Subject: FW: Y/51/17/DOC - Yapton Free Church

Further Drainage Engineers comments

Subject: RE: Y/51/17/DOC - Yapton Free Church

CLIENT		PROJECT	
Reg Hawks		Yapton Free Church, Yapton	
TITLE			
Proposed Drainage and Construction Details			
DRAWN		DATE	
M Glasgow		Jun 2017	
ENGINEER		CHECKED	
T. Zajac		BS	
SCALE		PROJECT NO.	
		22815	
		DWG No. REV.	
		201	
As Shown @ A1

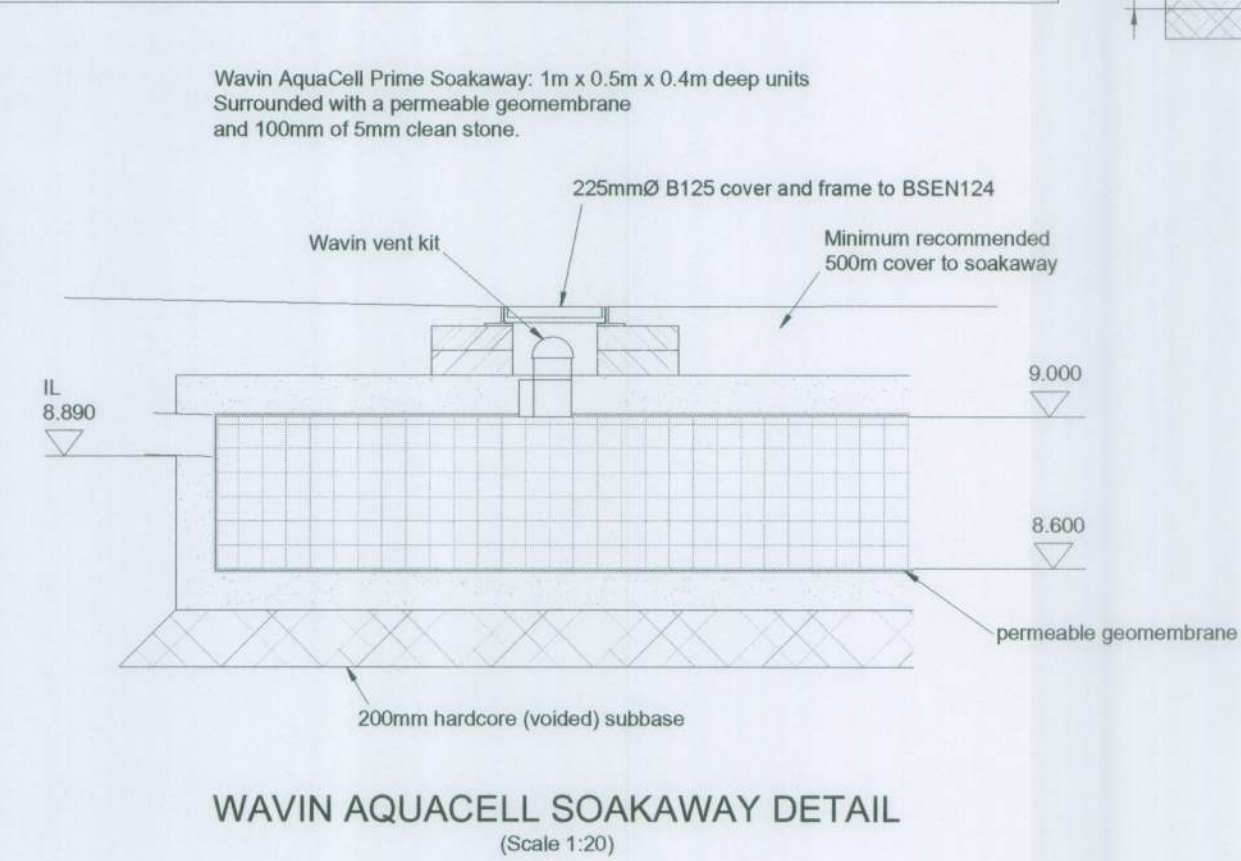
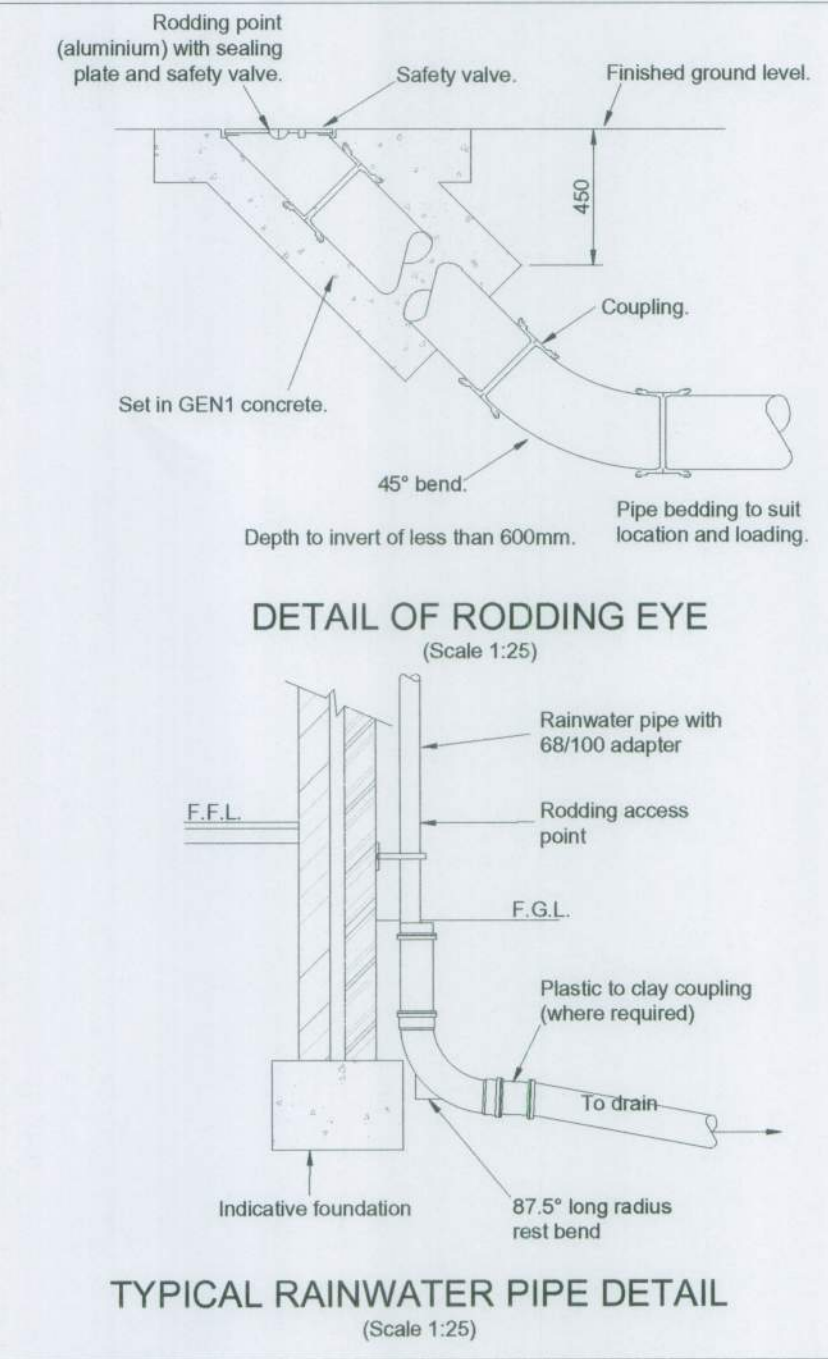
Test 2; the first two reading times are incorrect but we can assume these are 1340 and 1345. The depth reading at 20.45 should also be 523mm. As insufficient readings were taken ie. readings need to be taken to achieve at least the 75% depth ie. 675mm, I have had to do a bit of interpolation. The calculation gave a much poorer percolation rate than those rates used in the original soakaway design.

Based upon these results, I would suggest that an engineer re-looks at the design. As the third test was not carried out, a safety factor (to be agreed) will need to be applied to the worst percolation rate.
